#3 Suggested Condition of Approval Included in Planning Board Report Re: 415 Cumberland
emailed to Applicant 4/23/18.

Planning Board Public Hearing 04.28.2018

415 Cumberland Avenue, Building Renovation: Commercial & Residential

EXISTING WINDOWS TO BE REFURBISHED WHERE POSSIBLE, AND WHERE NECESSARY TO BE REPLACED WITH NEW WINDOWS TO MATCH EXISTING (NEW WINDOWS WILL BE DOUBLE GLAZED BUT WILL MATCH IN APPEARANCE)

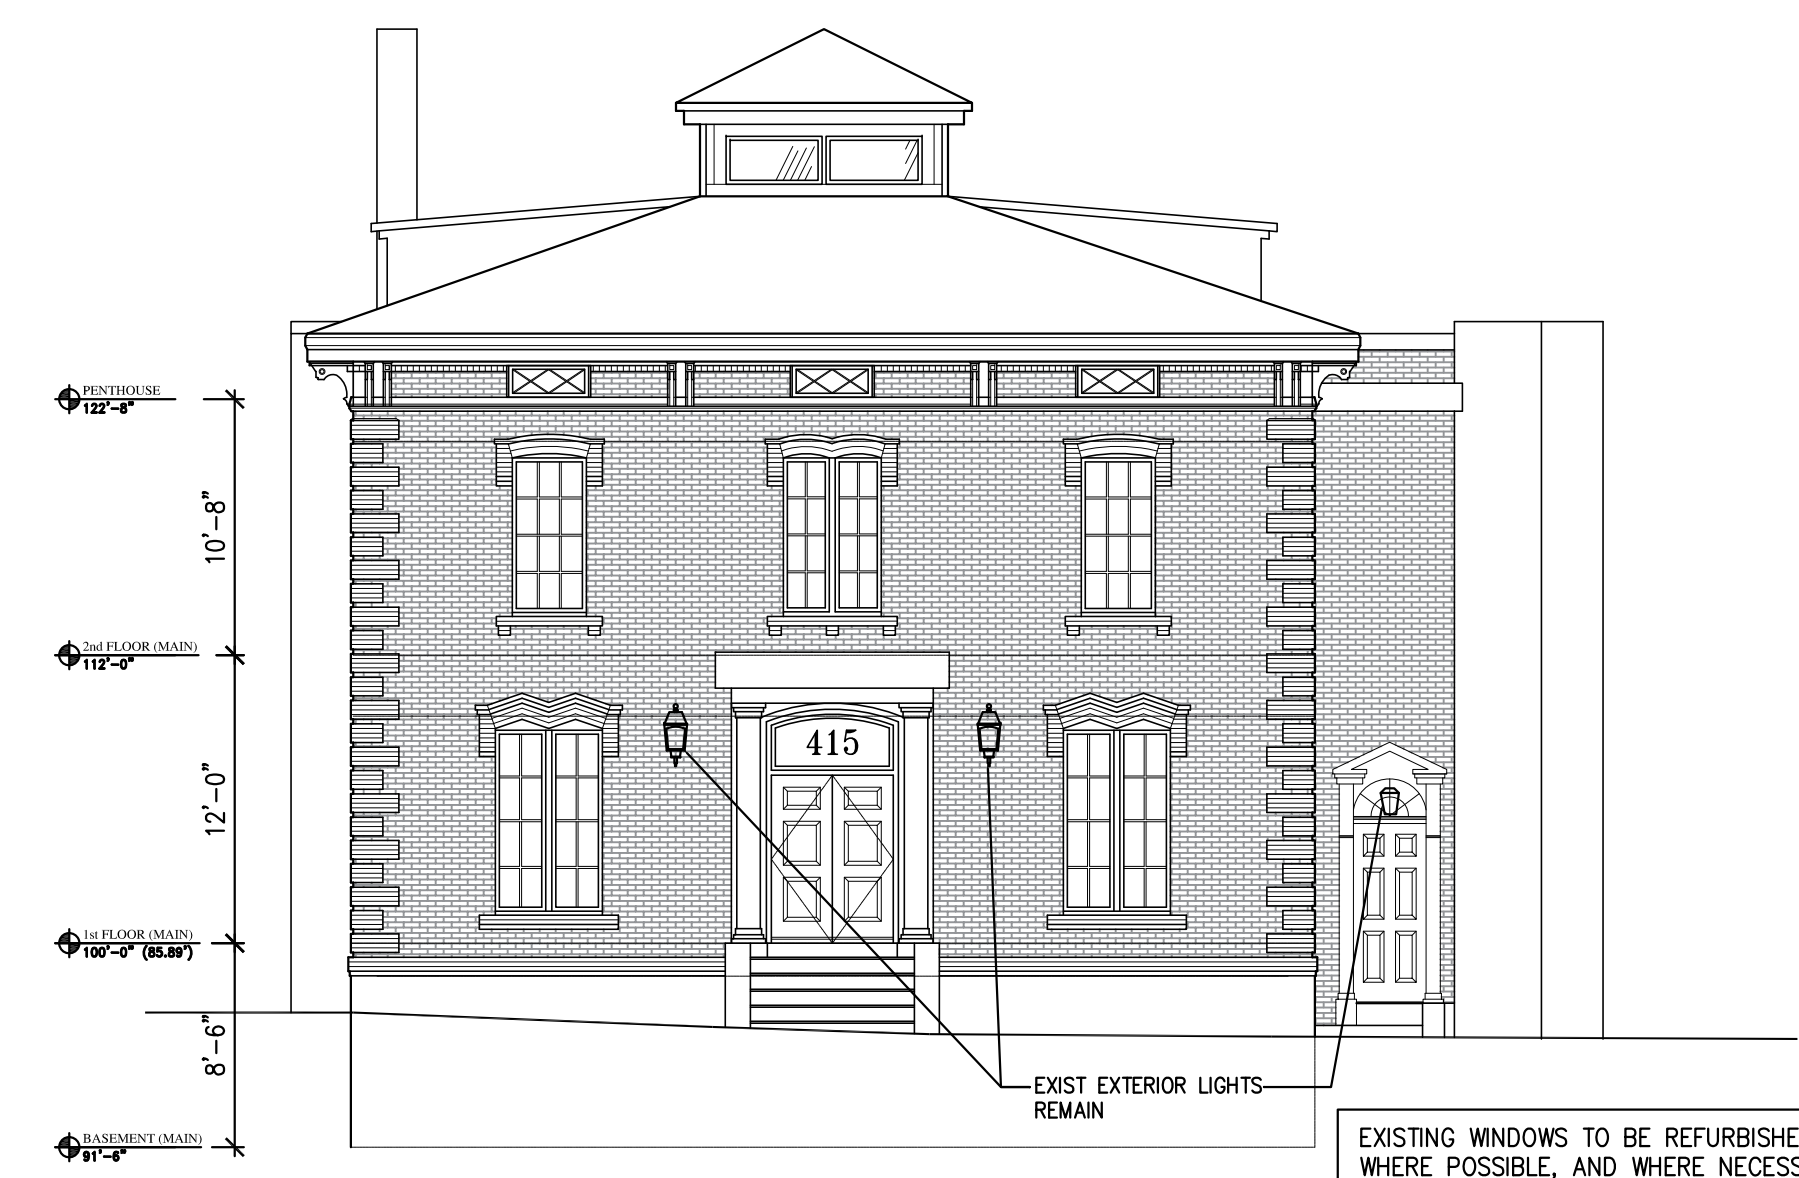
11. Please provide details on new windows. What are the materials? Windows should feature simulated divided lites with applied exterior muntins, at a minimum. Also, please identify which windows will be repaired and which will be replaced.

12. Please provide details regarding window moldings: will brick moldings be replicated in aluminum trim on other, new windows?
13. Why are two windows on the northwest elevation a different height than all other windows on that elevation and the Forest Avenue elevation? Ideally these will all match.

15. Please provide details regarding finishes. The painted finish of Hardie plank should not be high contrast, nor should the relationship of trim to the body of the building be high contrast.

16. Please specify the reveal / ttw of the Hardie plank. It should be less than 6."
17. Hardie plank shall be installed smooth side out. Please note this on plans.

18. Exhaust vents shall be painted to match the surrounding material (brick or Hardie plank siding). Please note this on plans.
19. Hardie plank at the top of the building parapets on the Forest Avenue and southwest elevations seems strange – the treatments / bands along the top of the building's middle section should be continued.

22. The coal chute on the Forest Avenue elevation shall be retained, not removed or covered. Please show this on plans.

The intent is to replace the 2nd floor windows in the brick building (residential units) and refurbish the 1st floor windows in the brick building (commercial spaces). All proposed windows in the clapboard building will be new. The revised elevations indicate which

Sheet Title:	<b>SITE PLAN</b>
--------------	------------------

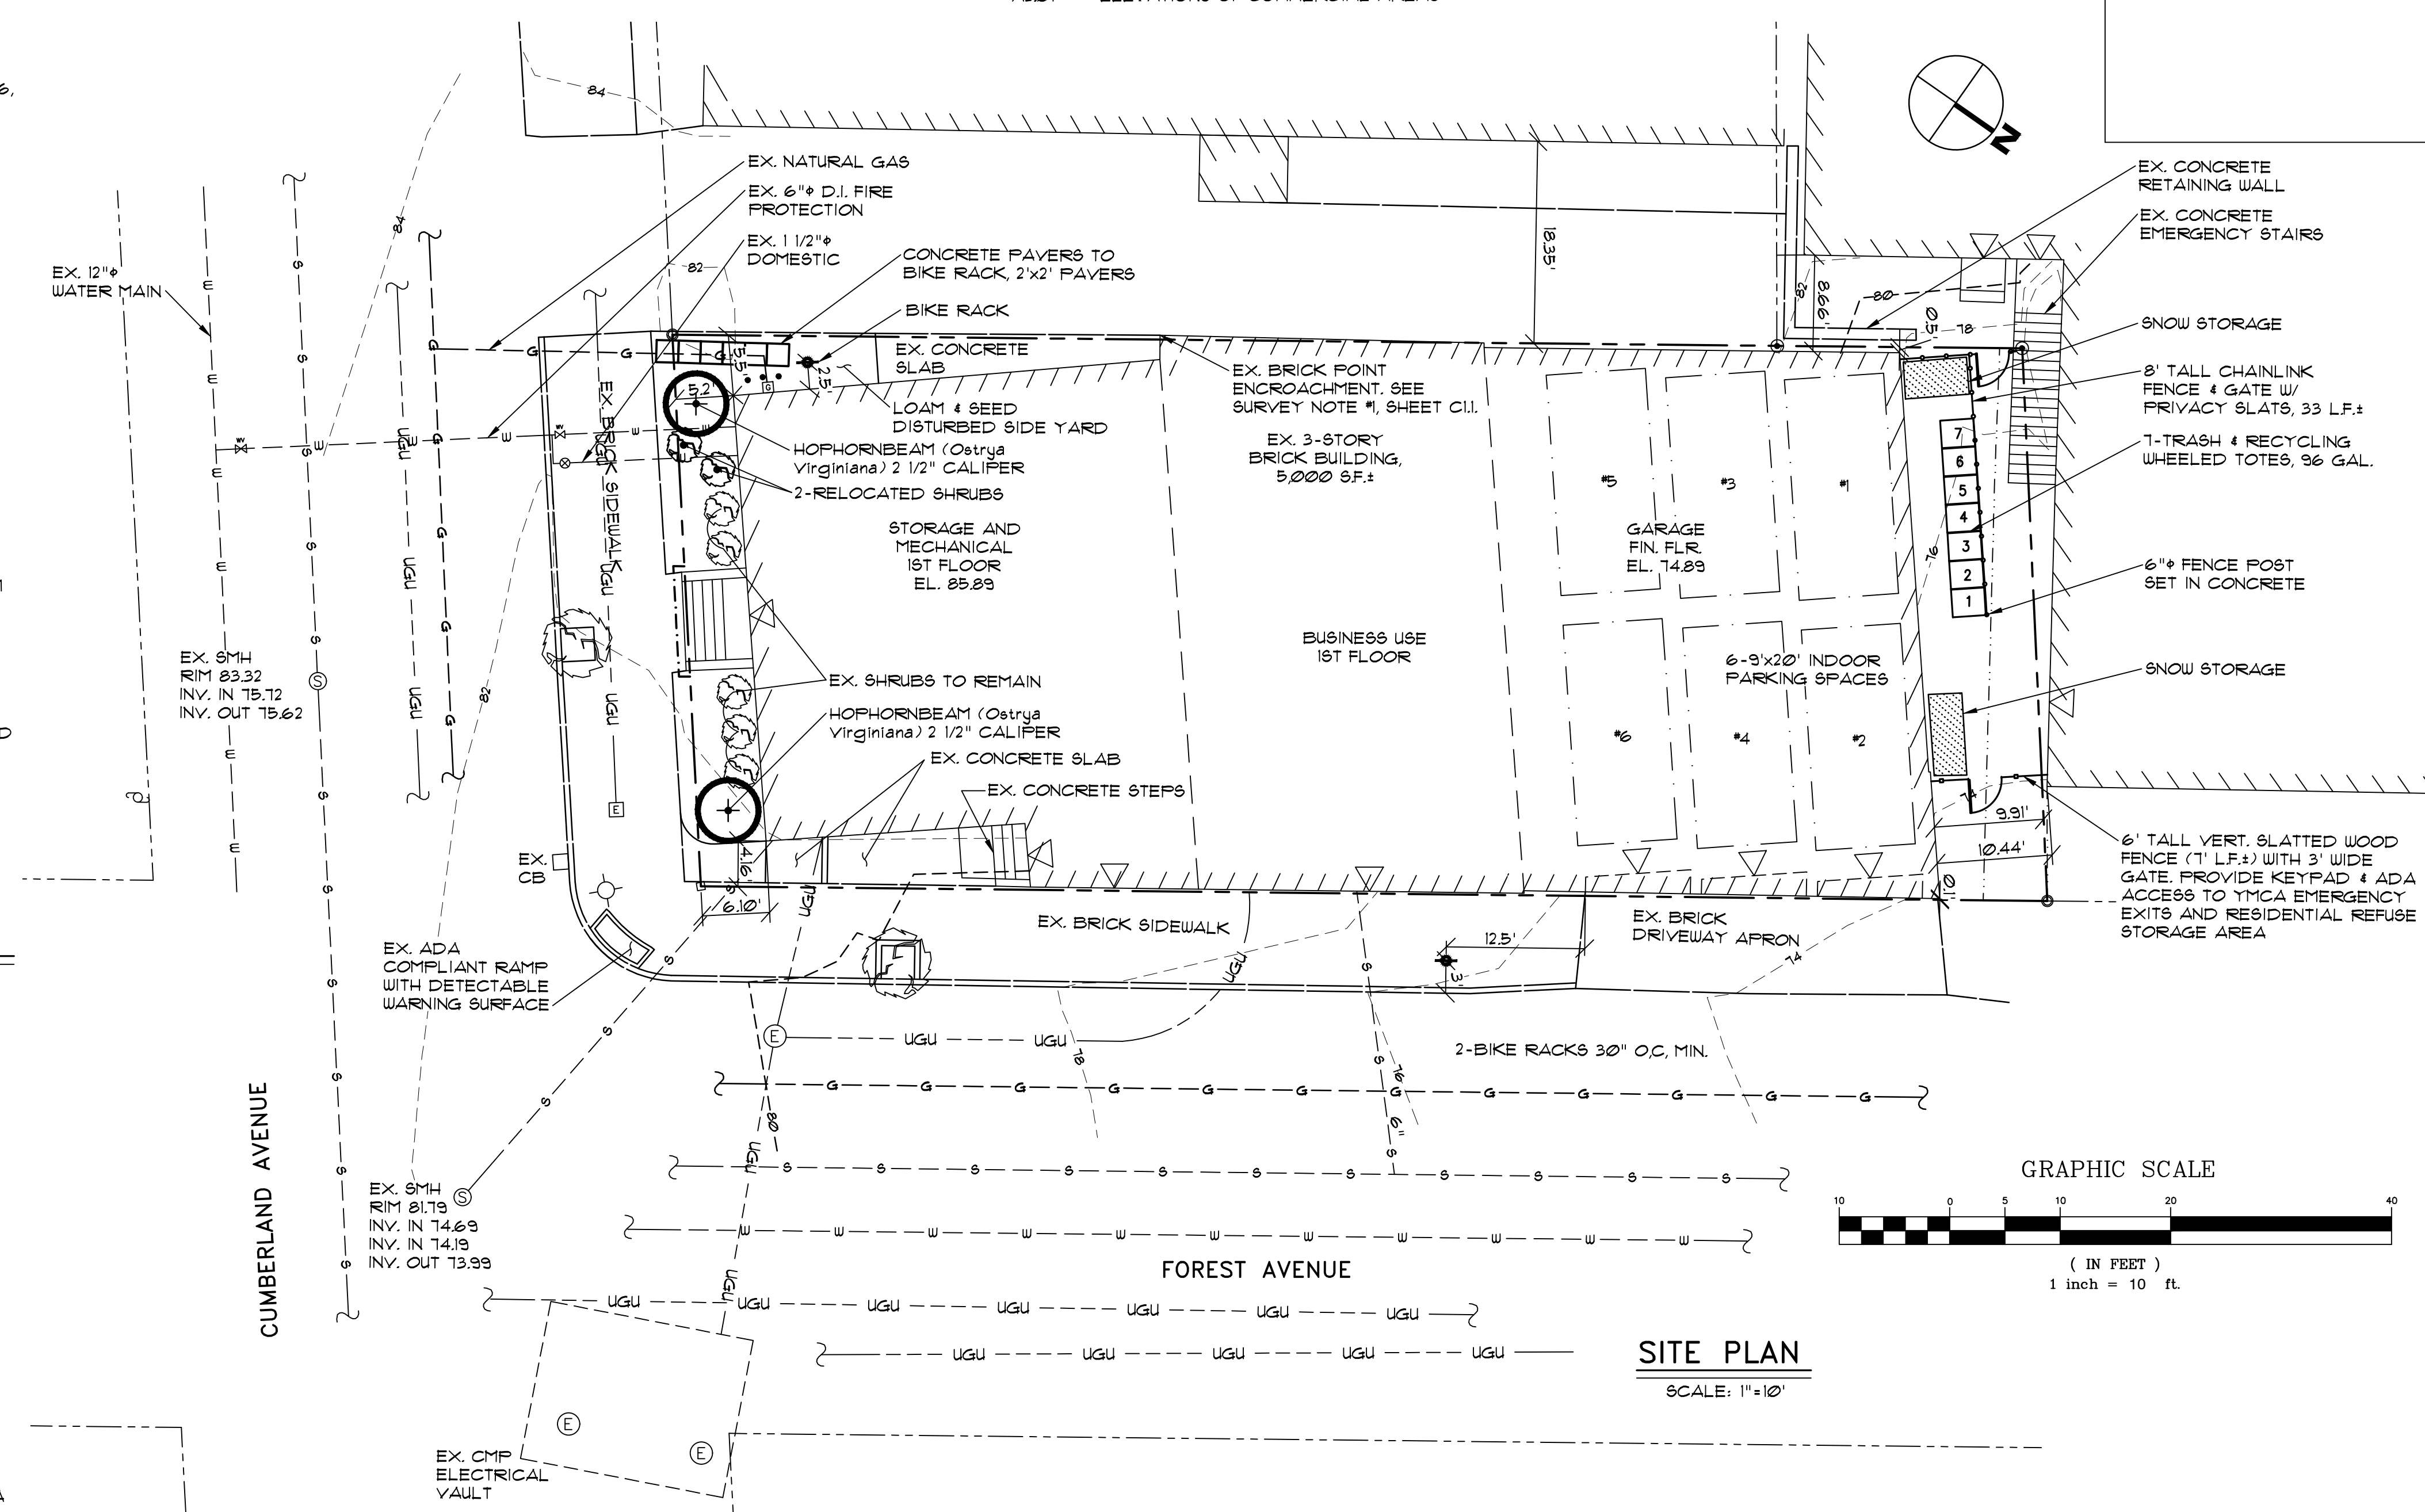
6. *The provided survey includes half the interior parking spaces detailed on the site plan. Please ensure consistency between documents and revise.*

9. *The layout and dimensions for the two bicycle racks need to be checked for adequacy. The minimum clearance (O.C.) are: from the building, 30"; between racks, 36"; and from the edge of the driveway, 24." Sufficient clearance from the exterior gas service and bollards also must be considered. It appears the bike racks would also block access to the external stairway from the second floor without going onto the adjacent property. Other bicycle rack locations on-site or within the sidewalk on either Forest and / or Cumberland Avenue can also be considered to make them more functional and not block this access.*

The bicycle racks have been revised. One is located on Forest Avenue and one off Cumberland Avenue.
